**Harnett County**  
420 McKinney Pkwy  
LILLINGTON, NC 27546  
Phone:  
Fax:

SUBJECT: **BRES2503-0004**  
**BUILDING RESIDENTIAL**

Here are the results of all Inspections located at **1814 JONESBORO RD:**

Proposed roof over existing deck

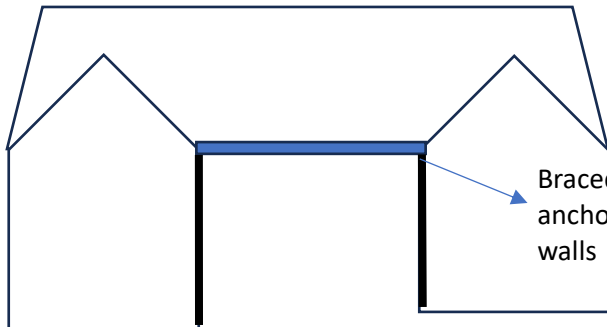
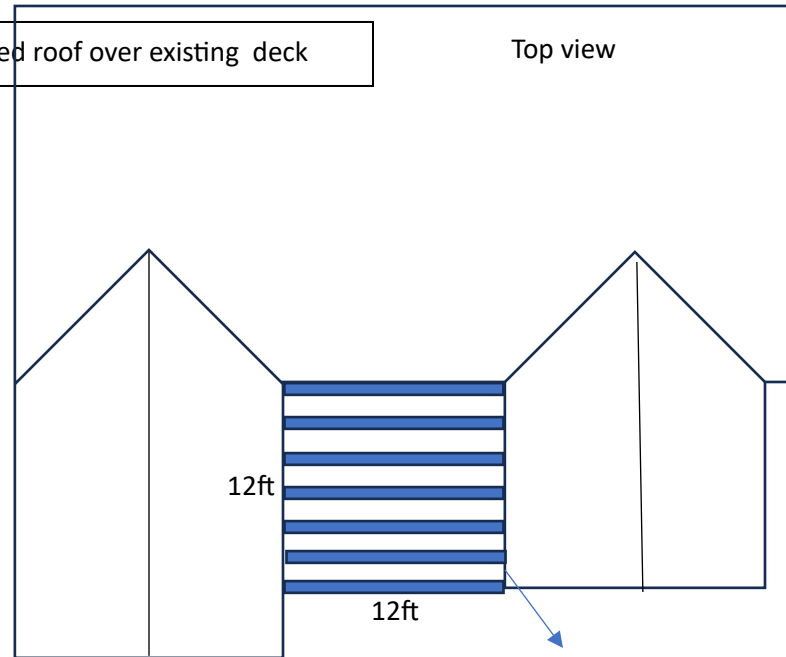
Inspection Type: ROUGH IN  
Scheduled Date/Time: 3/18/2025  
Completed Date/Time: 3/18/2025  
Inspector: Steven Gazlay  
Result: DISAPPROVED  
Remarks:  
Notes: Minimum roof slope not met(see approved plan). Cannot pond water onto existing roof. Roofing not complete.

Inspection Type: FINAL\*\*  
Scheduled Date/Time: 3/31/2025  
Completed Date/Time: 3/31/2025  
Inspector: Steven Gazlay  
Result: DISAPPROVED  
Remarks: eTRAKiT Inspection Request  
Notes: Roof not pitched per approved plan.
